File No: R/2014/27
Your Ref: SSD 6371

RE: SSD 6371 – 175-177 Cleveland Street, Redfern

I refer to your correspondence received on 8 July 2014, inviting Council to make a submission regarding the proposal for a mixed use development at 175-177 Cleveland Street, Redfern.

GROUND FLOOR PLAN @ 1:200

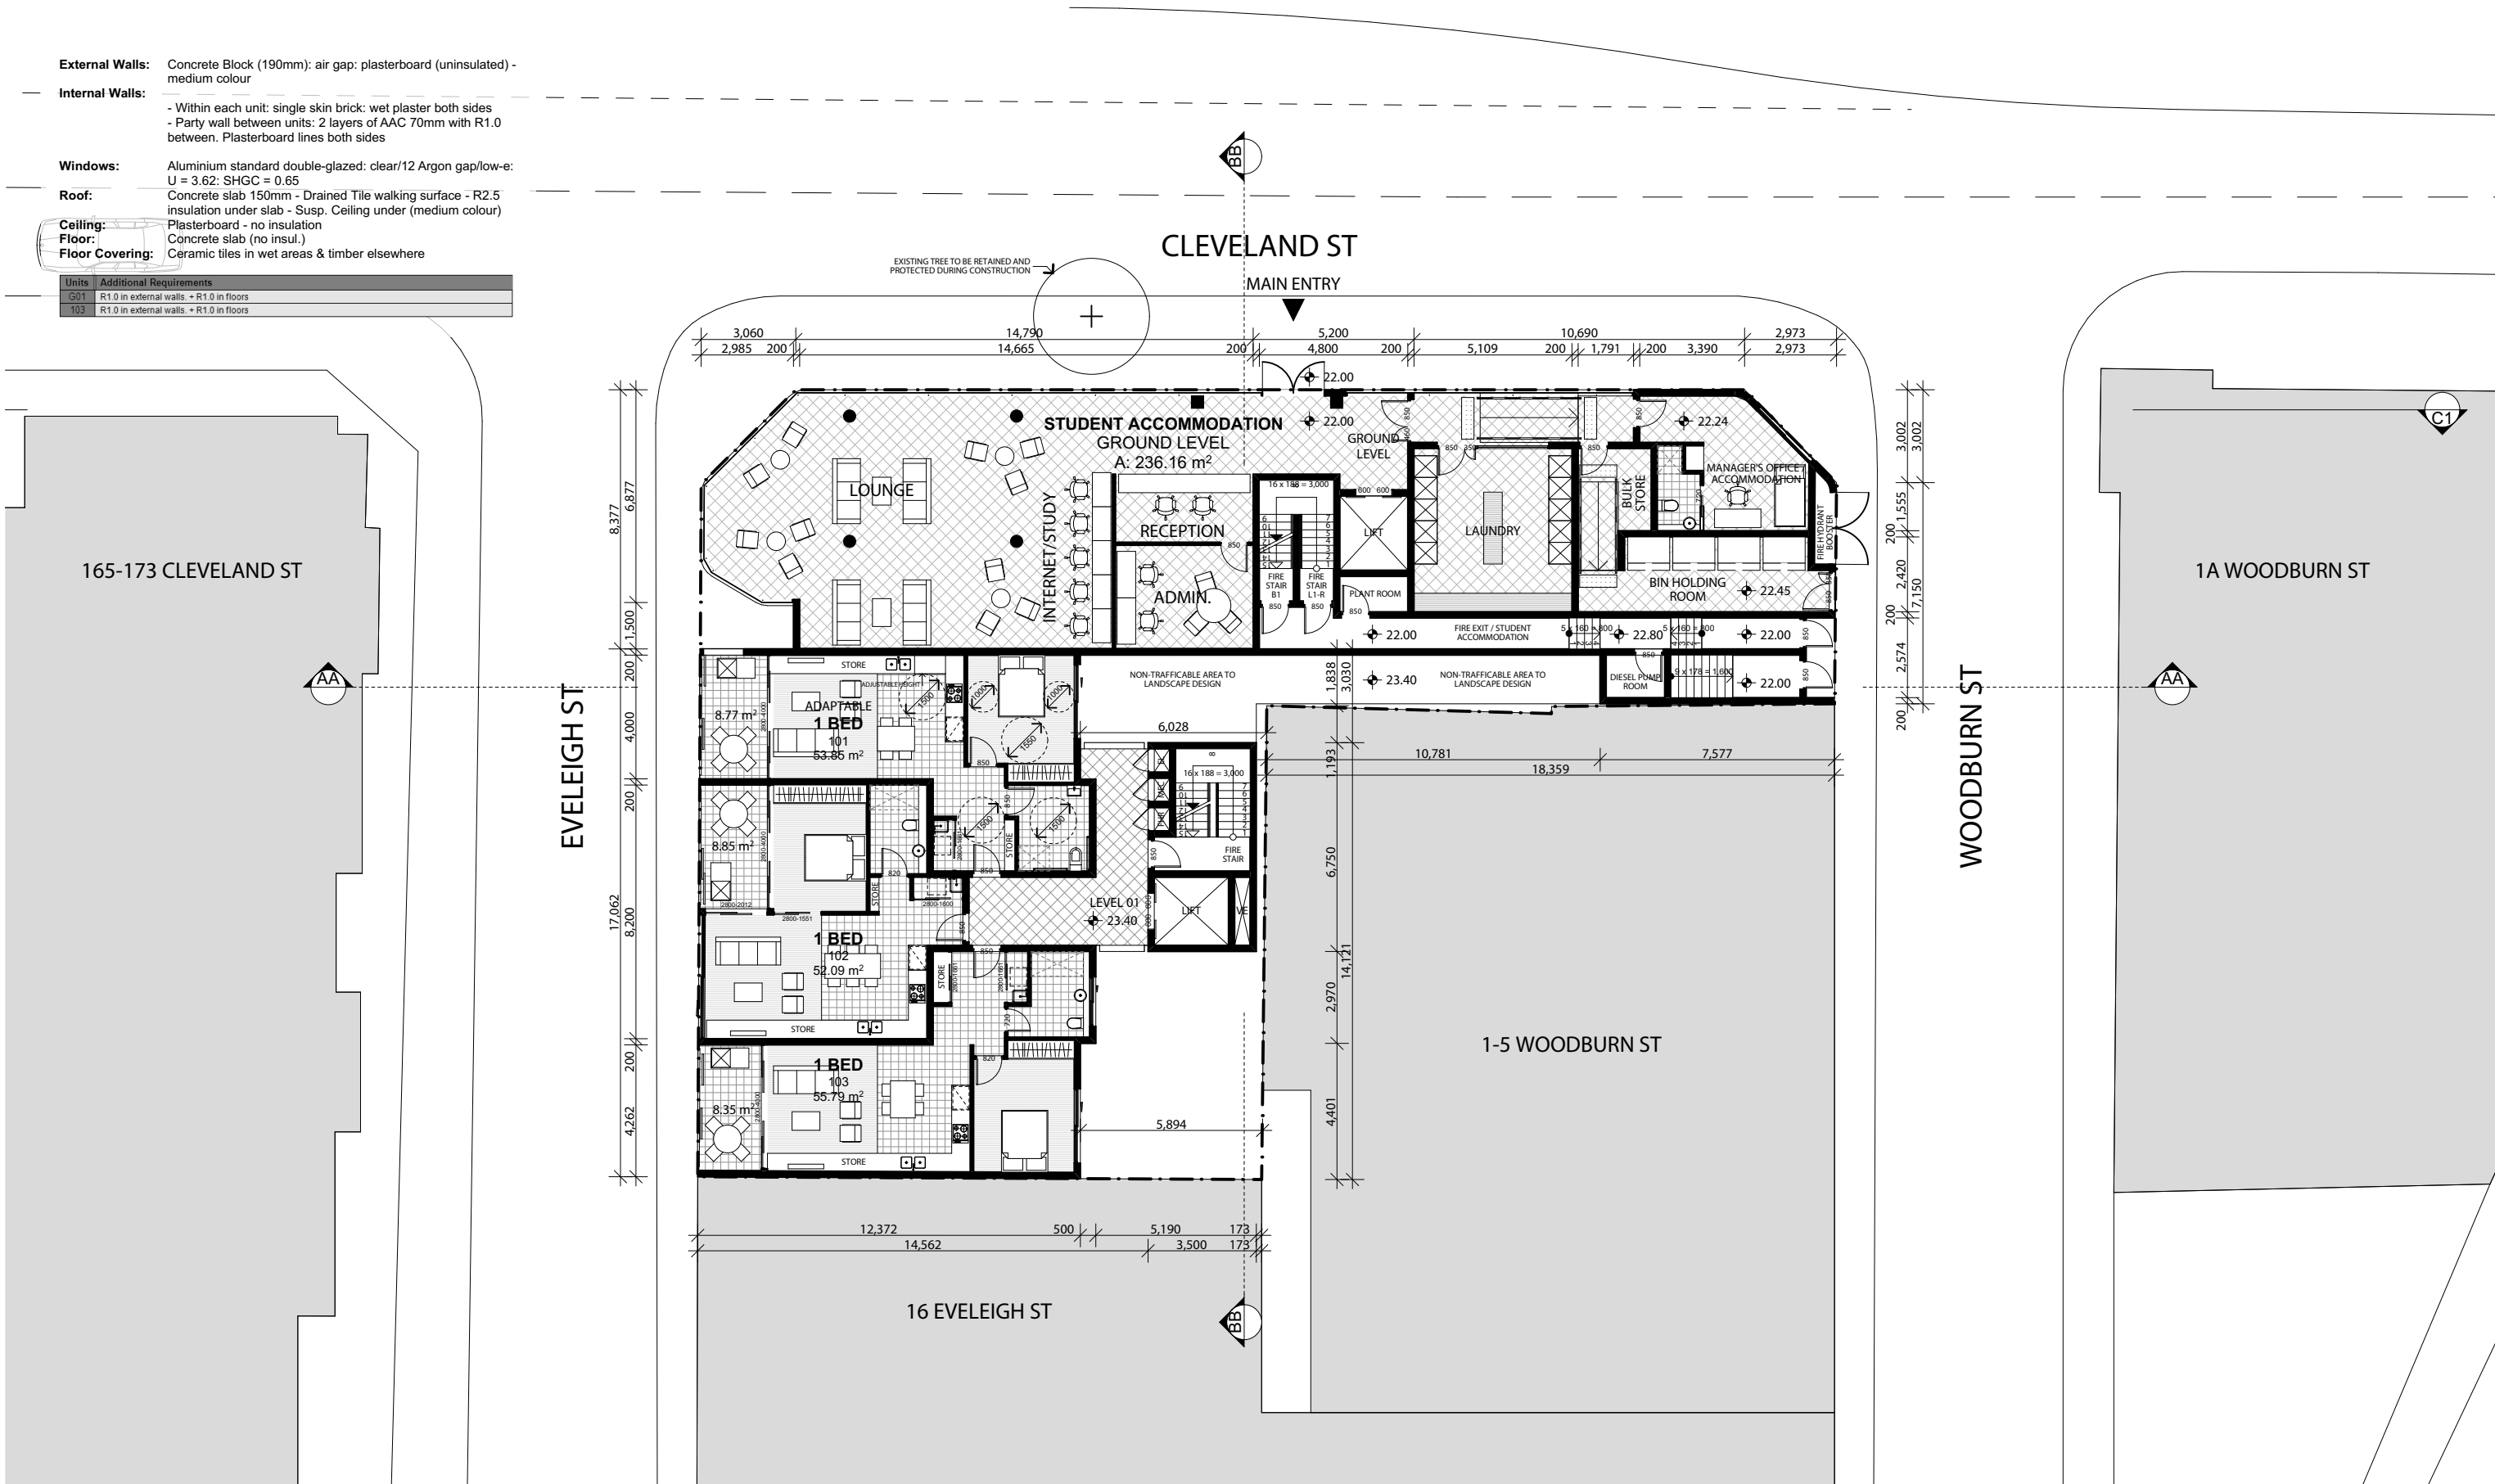
The use of a variety of materials for the residential flat building component of the development, including polished concrete and zinc cladding is also supported. It is noted however that no materials or finishes have been specified for the ground floor balustrades to the balcony of apartment G01 and the access ramp. Further, while no objection is made to the frameless glass balustrades to the balconies, potential exists for privacy of these areas to be compromised. The use of translucent glazing should be considered in these areas.

Pedestrian access to the student accommodation component of the development is proposed via Cleveland Street. Plans show this entry located directly on the property boundary and do not include any ramping. As currently proposed, this entry may present accessibility issues, as the as the pavement on Cleveland Street has a gradient of greater than 1:20.

LEVEL 02
SCALE 1:200

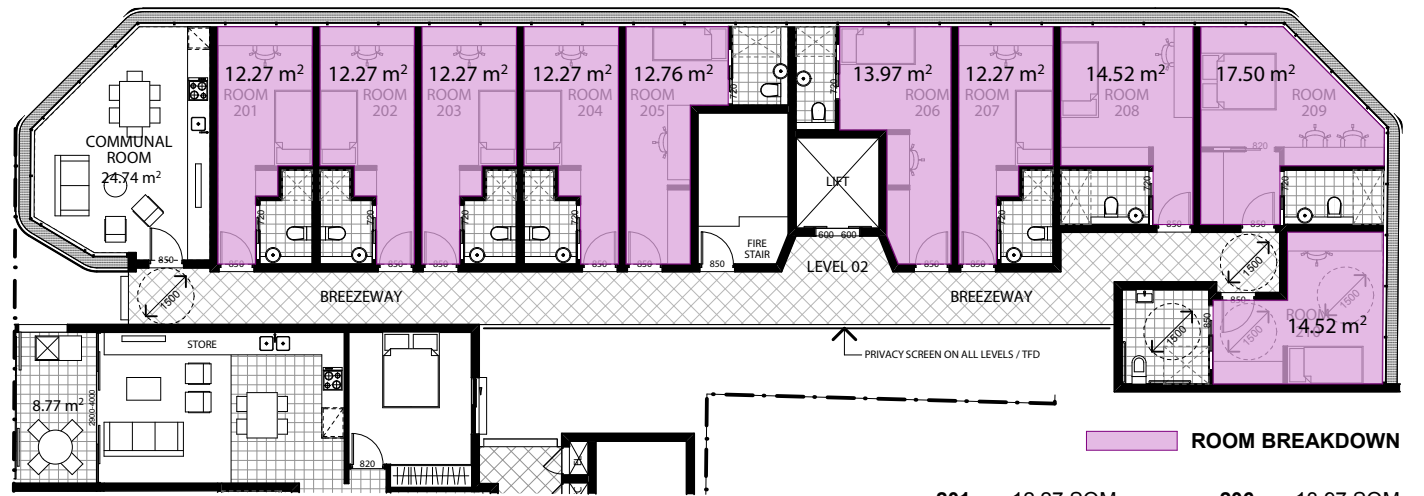
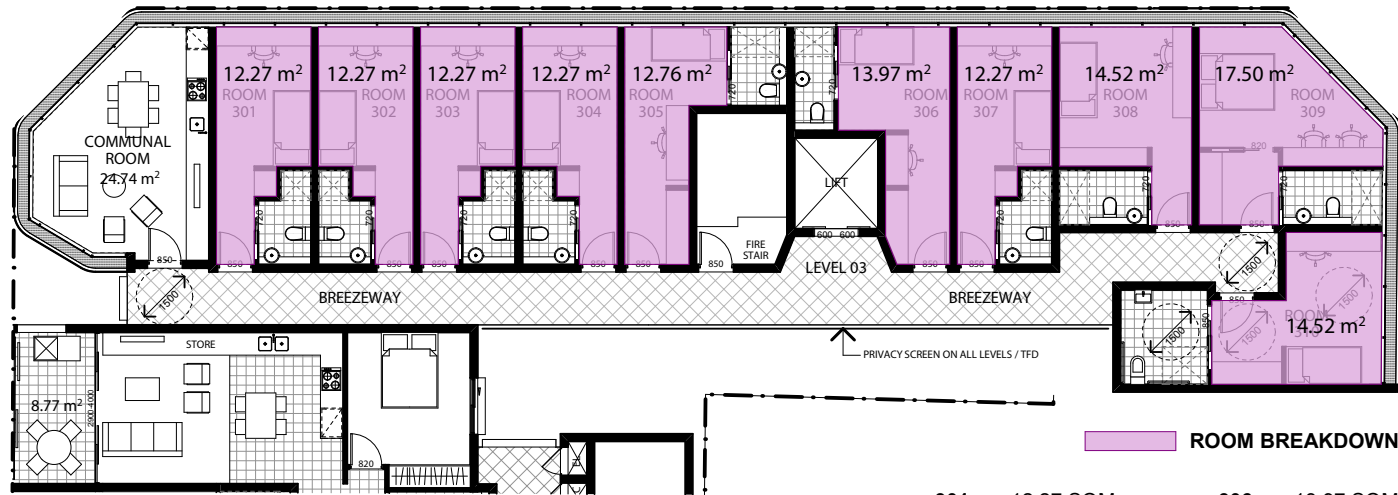
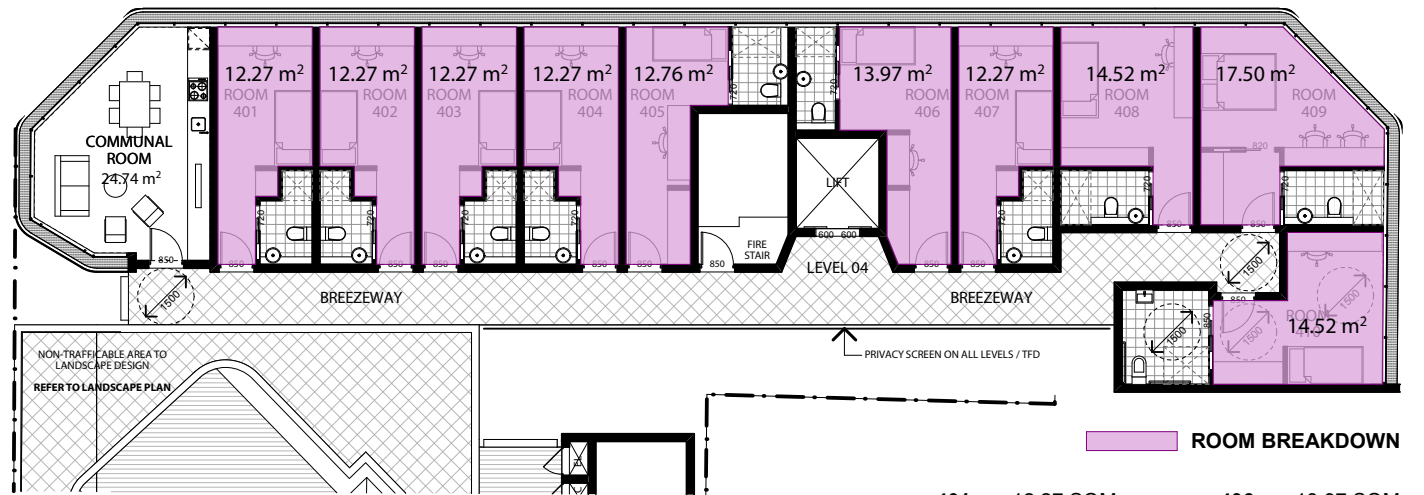
The Statement of Environmental Effects prepared by Sutherland and Associates Planning states that bedrooms within the student accommodation component are a minimum of 12m² and en suites are a minimum of 2.1m², as required by Sydney Development Control Plan 2012. A preliminary review of these areas indicates that some rooms may fall under this size.

ROOF GARDEN @ 1:200

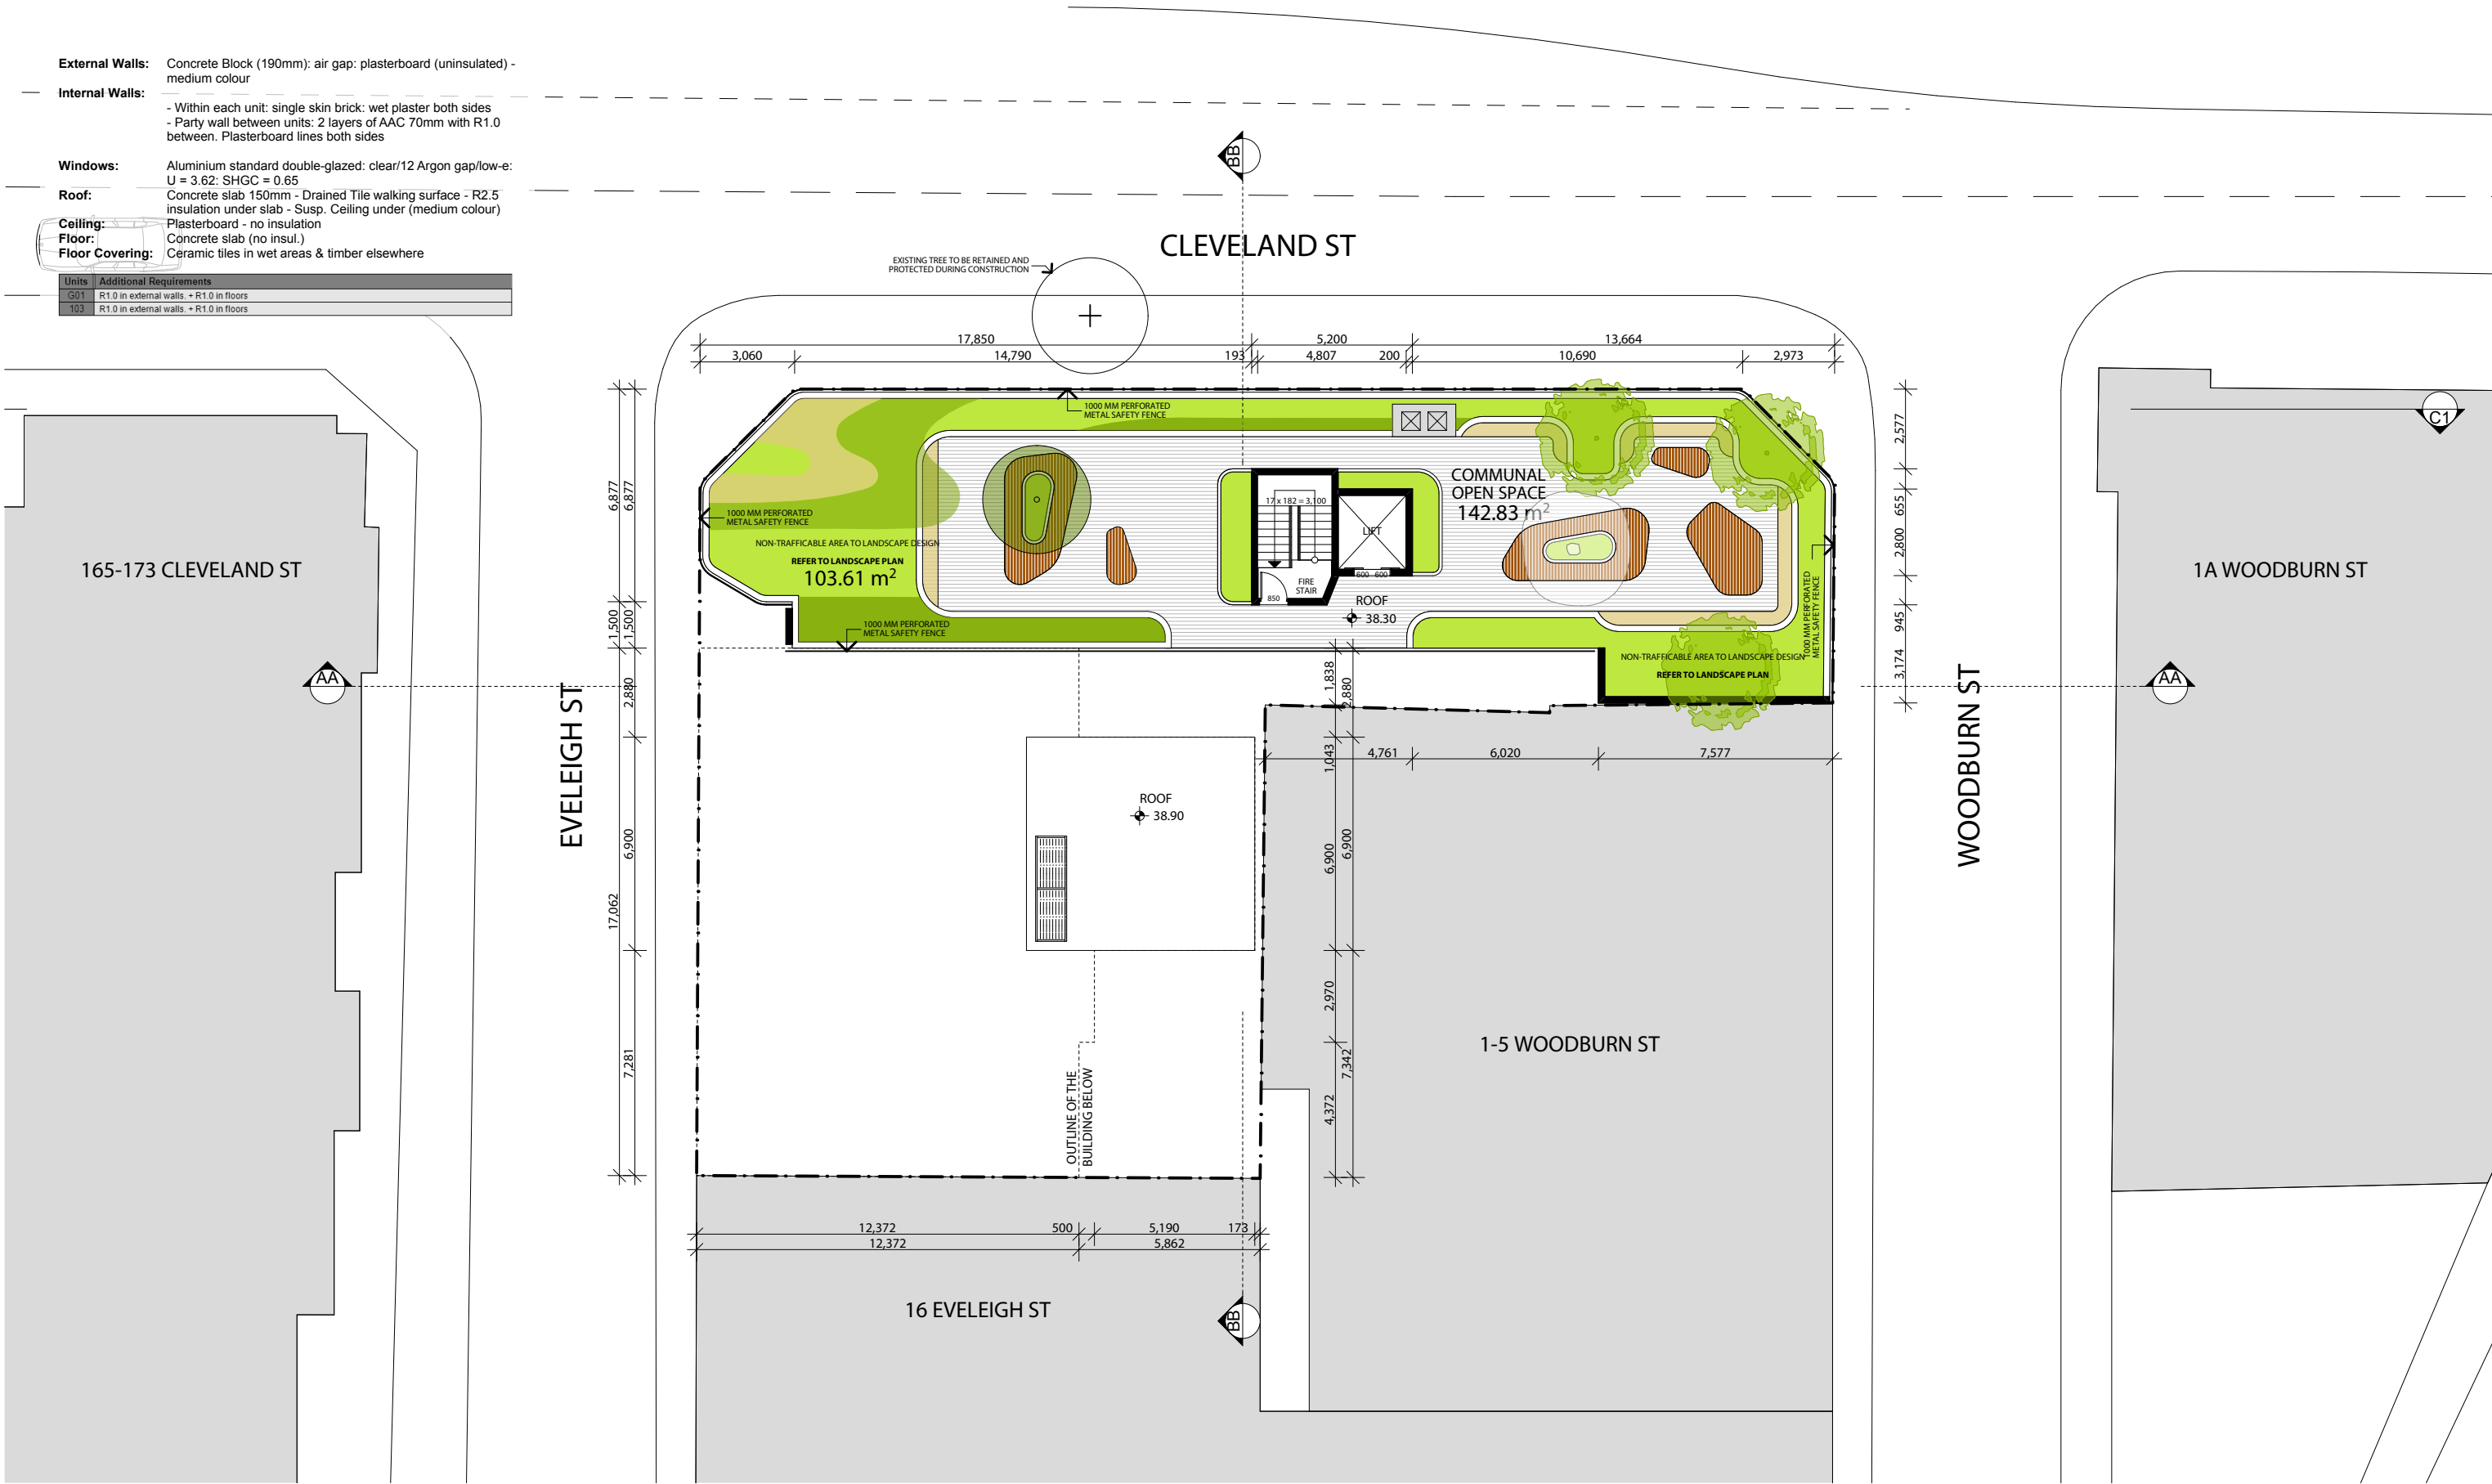
It is noted that a plant room is proposed within the basement level and no plant has been located on the roof. Clarification should be sought as to whether any plant is to be located on the roof. Rooftop structures such as plant rooms, air conditioning and ventilation systems should be incorporated into the design of the building by

It is noted that planting is provided on the roof terraces in wide planter beds to deter access to the edge of the roof. However additional 1m high guarding should be provided on top of the parapet to protect from the additional fall height created by the garden bed, or an alternative arrangement of garden beds should be provided.
